Planning Inspectorate

East Midlands Gateway phase 2 – BC0410001

Section 51 advice regarding draft application documents

Issued on 01 April 2025

Figure 1: Site Location, River Mease & Mease Rivers Operational Catchment

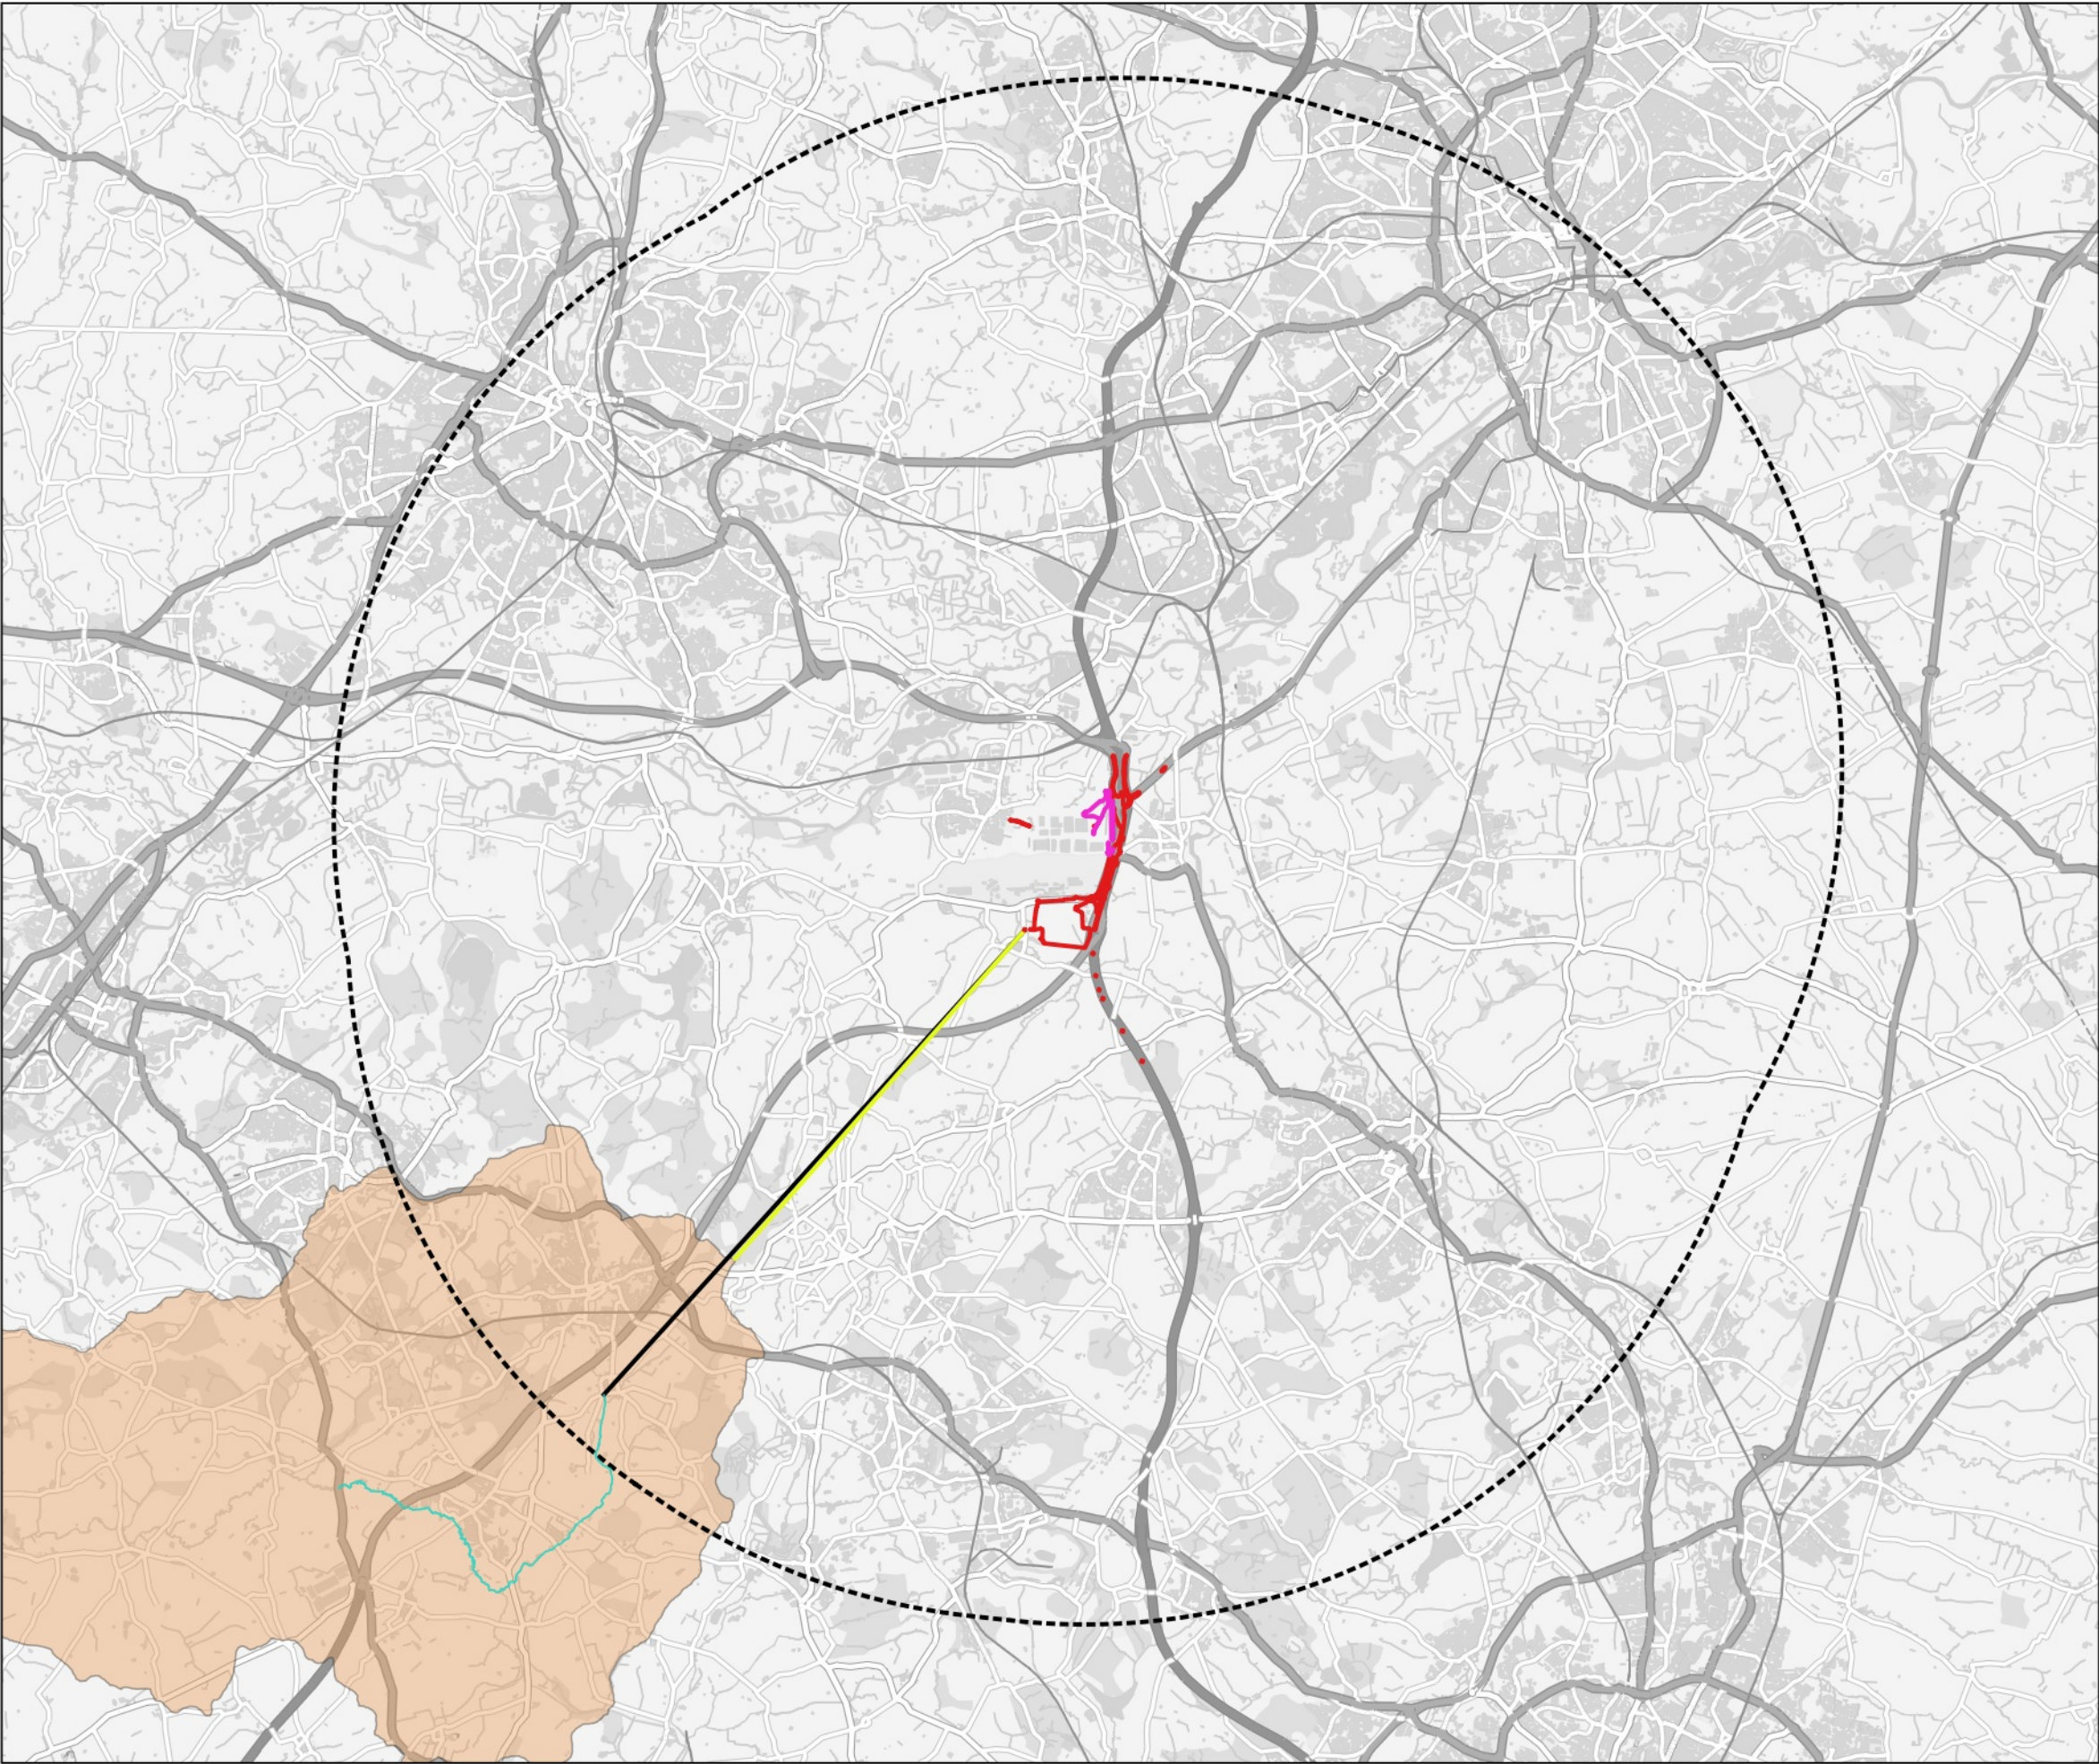
Ref No.	Paragraph / Section	Comment or question
3.	Figure 1	With reference to ID 2 above, Figure 1 is not consistent with the plans supplied as draft works plans and draft land plans in that it appears to show work associated with the material change / DCO application as well as the dDCO but this is not set out in the way the document is structured. The HRA report should therefore be clear whether it is intended to support both applications and if so, the plans amended to demonstrate this.
